THE SIZEWELL C PROJECT

POST HEARING SUBMISSIONS INCLUDING WRITTEN SUBMISSIONS OF ORAL CASE SUBMITTED BY THE HEVENINGHAM HALL ESTATE

TRAFFIC AND TRANSPORT

DRAWING TITLE:
 YOXFORD ROUNDABOUT
 PROPOSED GENERAL ARRANGEMENT

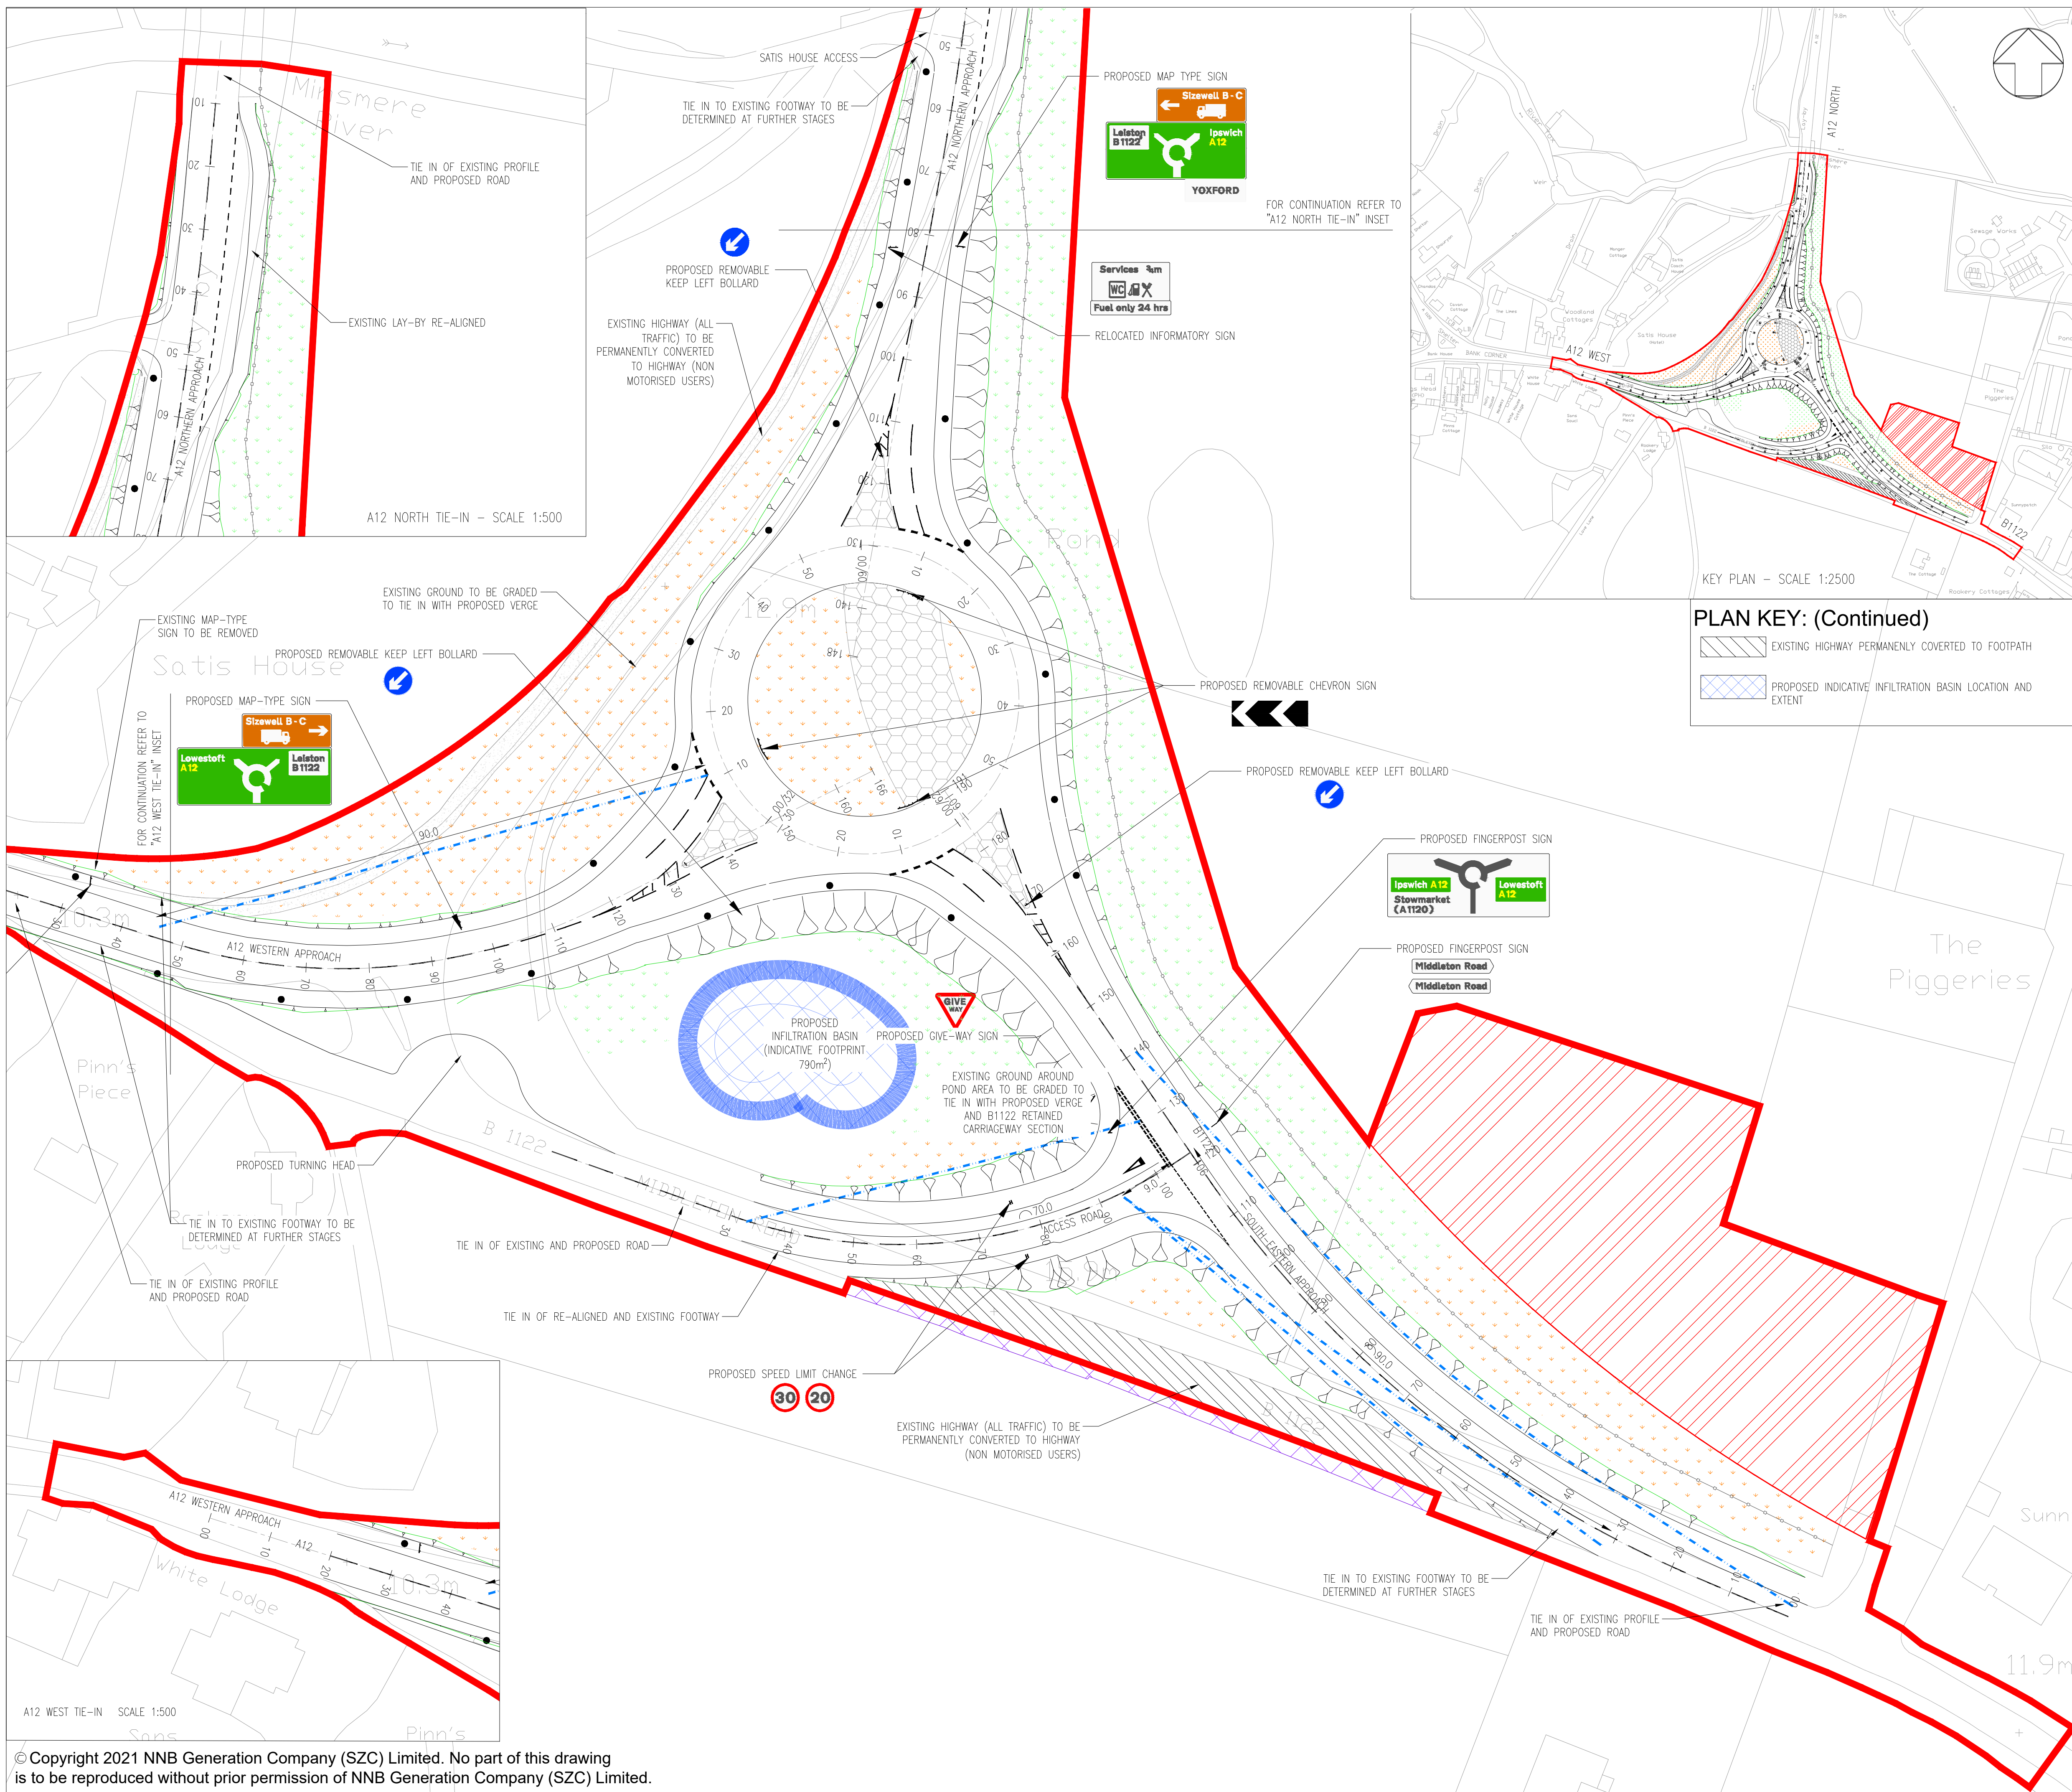
- 2.1 The HHE made two points regarding the movement of freight by AILs and the design of the Yoxford Roundabout at ISH2.
- 2.2 First, the Applicant has not justified the need for a 55 metre Inscribed Circle Diameter (**ICD**) roundabout at the junction between the A12 and the B1122 to offset the impact of the Sizewell C Project (the **Project**). As detailed in the HHE's Written Representation (**EXL REP2-287**), Transport Planning Associates (**TPA**), the HHE's transport consultants, consider a 40 metre ICD roundabout to be acceptable. Noting the requirement to accommodate AILs, TPA have also tested the possible swept path of a 27.6 metre long AIL vehicle. For further details see:

- 2.3 A smaller roundabout would require significantly less land, and would have a reduced impact on landscape, the historic environment and ecology.

- 2.4 In its oral response to the HHE's question, the Applicant simply asserted that a 55 metre ICD roundabout would function adequately and that this has been agreed by the host local authorities. With respect, that is no answer to the point the HHE makes. The roundabout is bigger than it needs to be. TPA have demonstrated this with reference to a 40 metre ICD roundabout, which would be less harmful. The HHE has asked why the Applicant believes a 40 metre ICD roundabout would not function equally well and, unless and until a meaningful response is provided, the assumption must be that there is no answer to the expert evidence of TPA. Second, the Applicant has been inconsistent in its approach to AIL provision, as illustrated by comparing the drawings for the proposed Yoxford Roundabout at the junction between the A12 and the B1122 and the roundabout at the junction between the Sizewell Link Road and the B1122. See:

- 2.5 The roundabout at the junction between the Sizewell Link Road and the B1122 does not appear to be suitable for AILs, yet the design of the Yoxford Roundabout between the A12 and B1122 includes AIL features. No explanation has been provided and it is unclear whether the difference in approach is deliberate or an omission.

- 2.6 The Applicant agreed to respond to the above design points raised by the HHE at Deadline 5, namely why a smaller 40 metre ICD roundabout has not been considered by the Applicant and the rationale behind the different design for the junction between the Sizewell Link Road and the B1122 and the Yoxford Roundabout in terms of AIL provision.
